PLOT PLAN CHECK LIST:

APPLICATION FOR A SPECIAL USE PERMIT
PLOT PLAN
FOR
SCHUBERT RANCH SAND RESOURCE
ELLICOTT, COLORADO

ELLICOTT SAND AND GRAVEL LLC

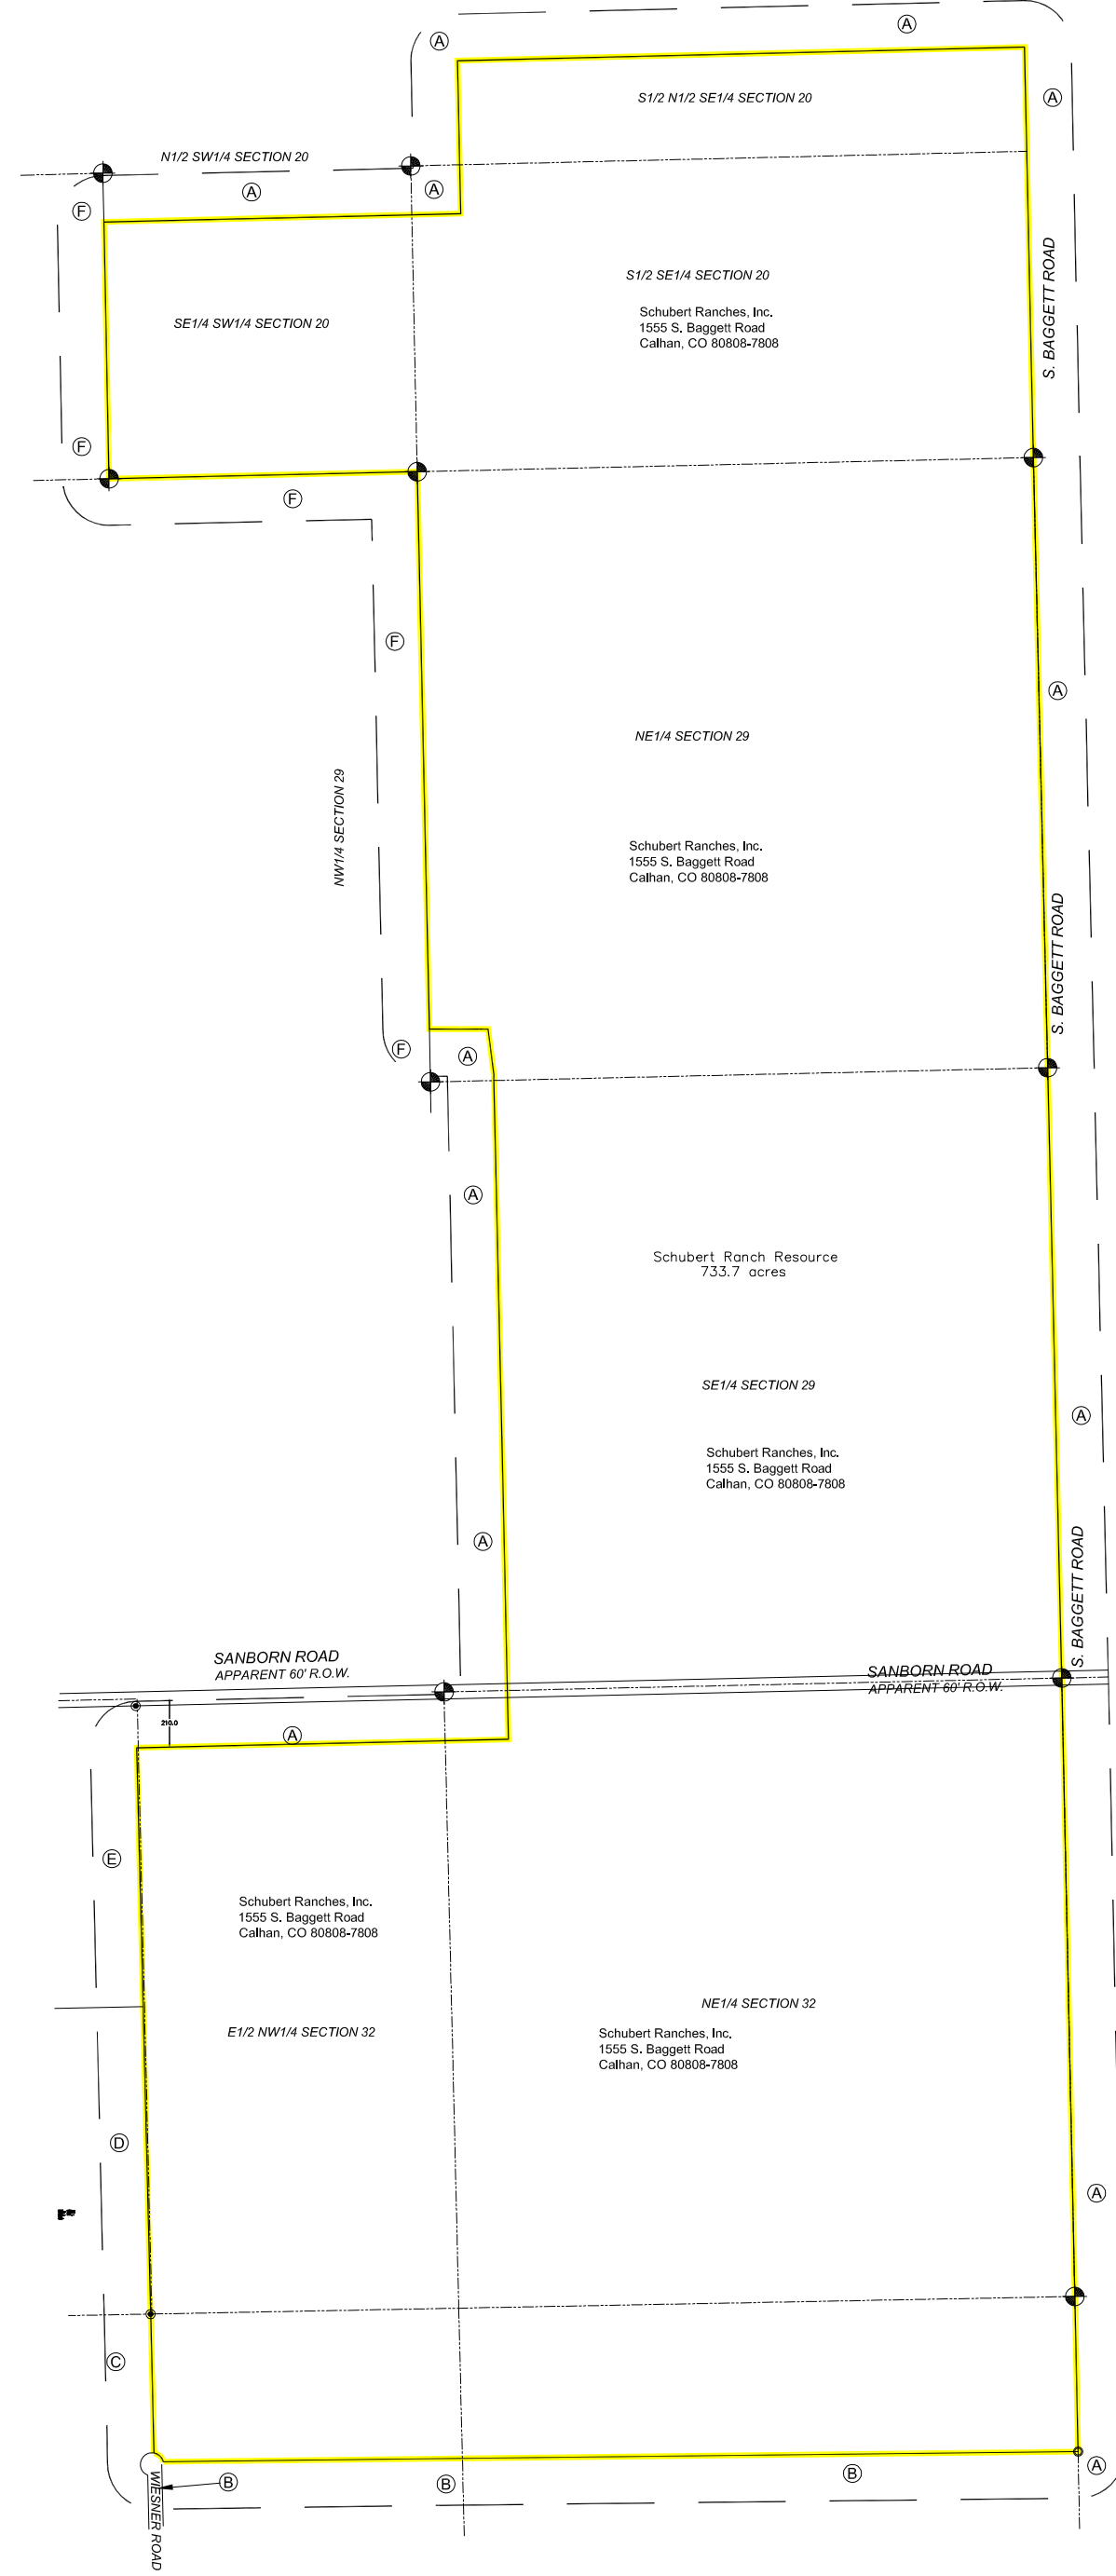
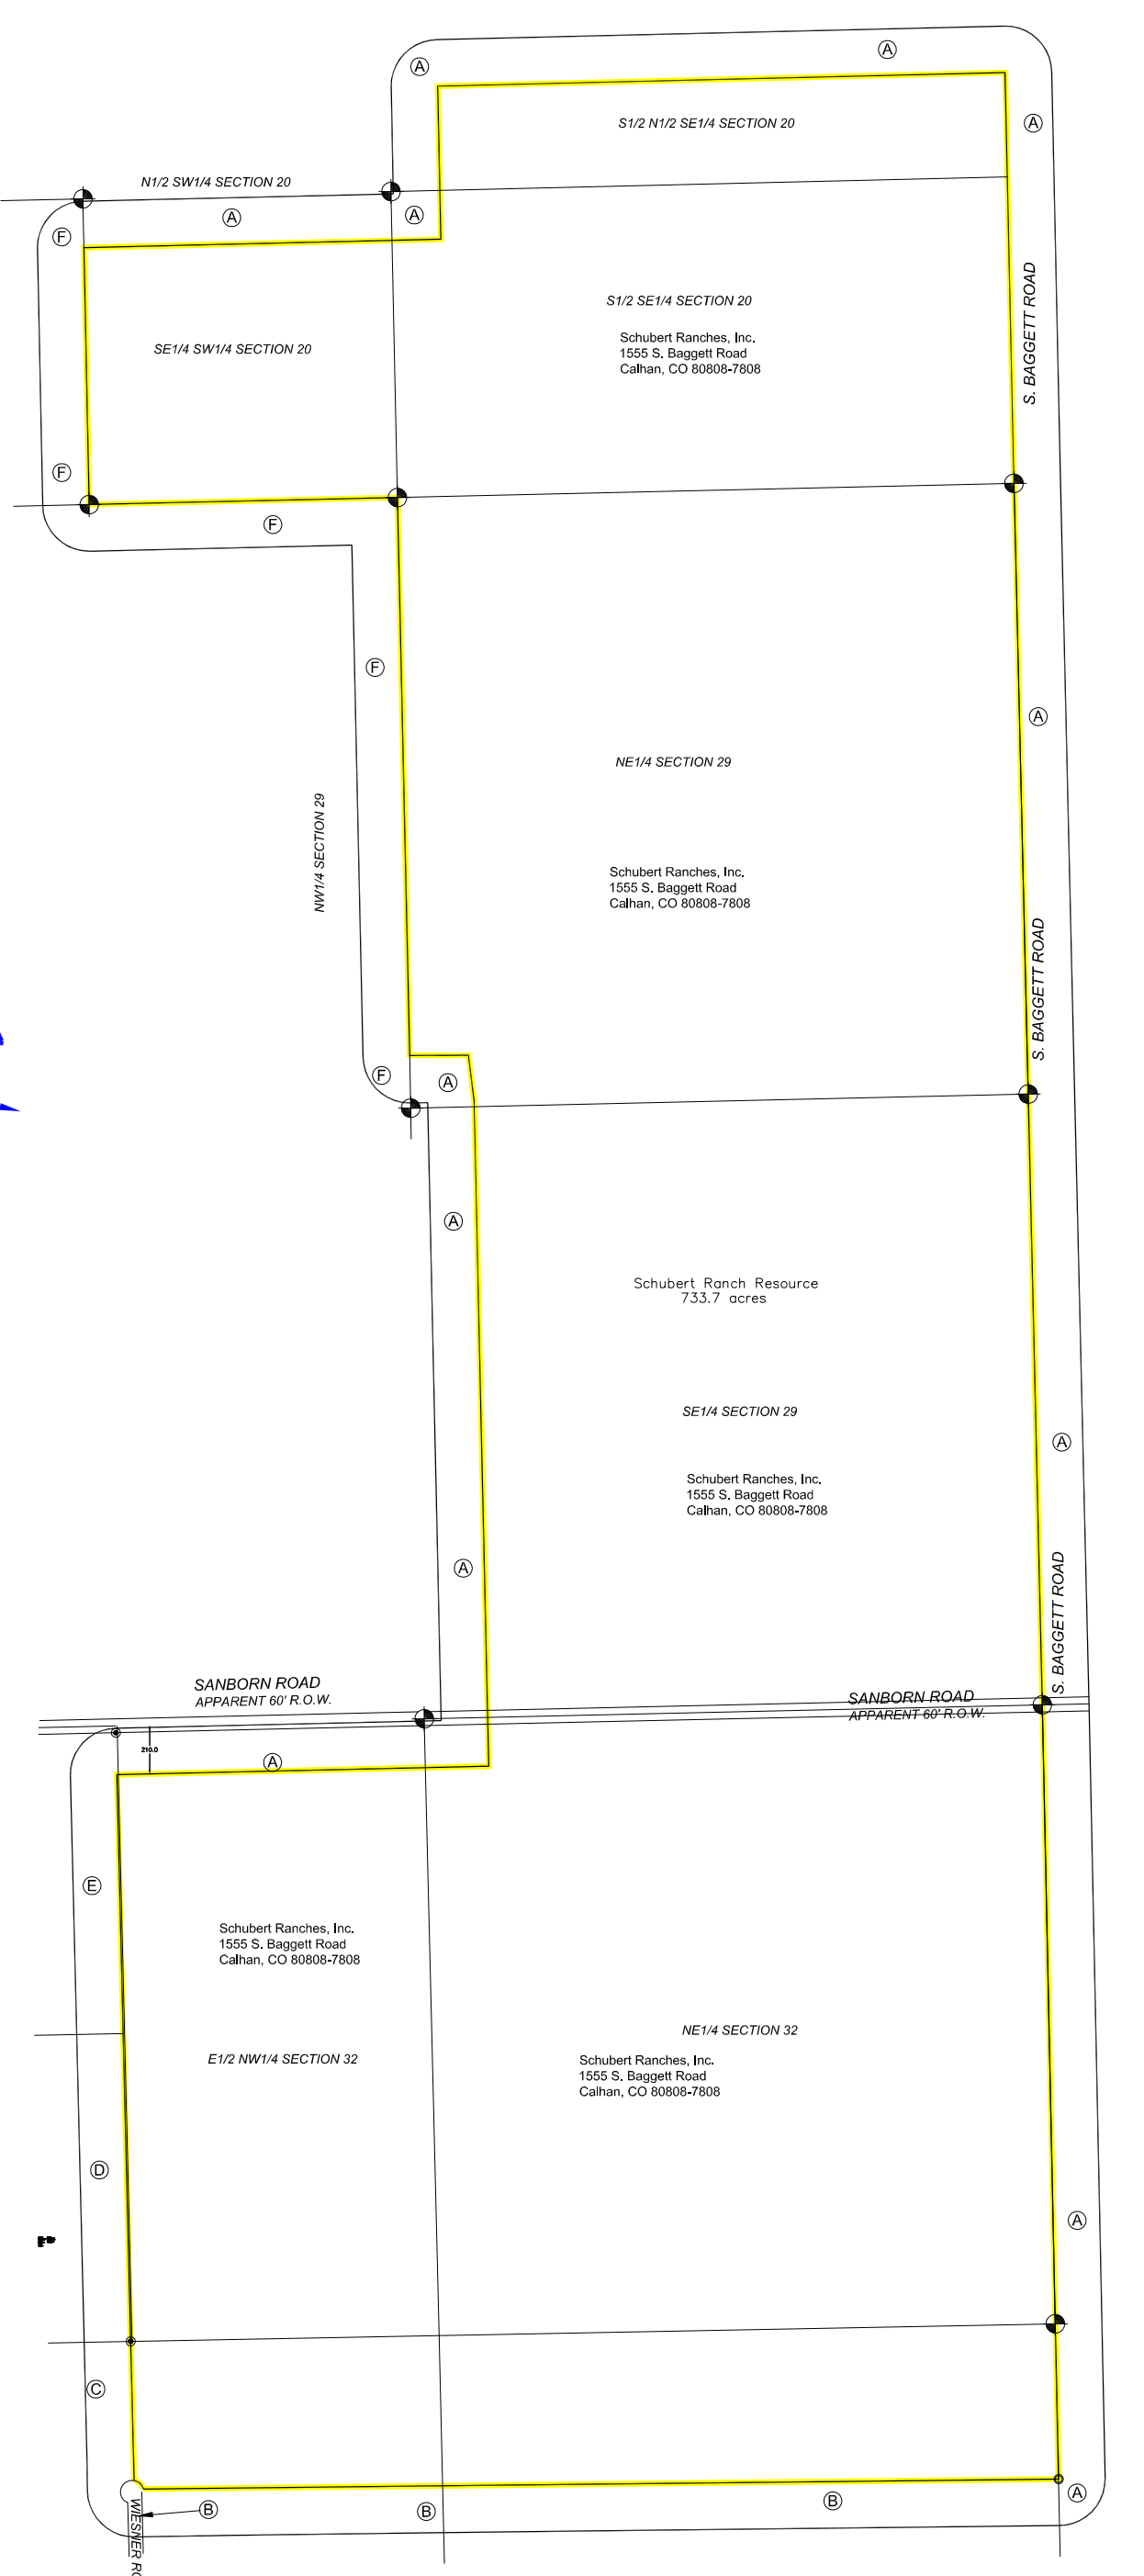
Please verify that this submittal is accurate. it seem to be different than what is shown on the state DMRS website. There are many 200 ft setbacks on the information provide to the state that are not show on this plot plan. it appears that you will be mining right up to the adjacent property line. please show a larger setback or provide a letters from the adjacent neighbors stating that the zero foot setback is okay.
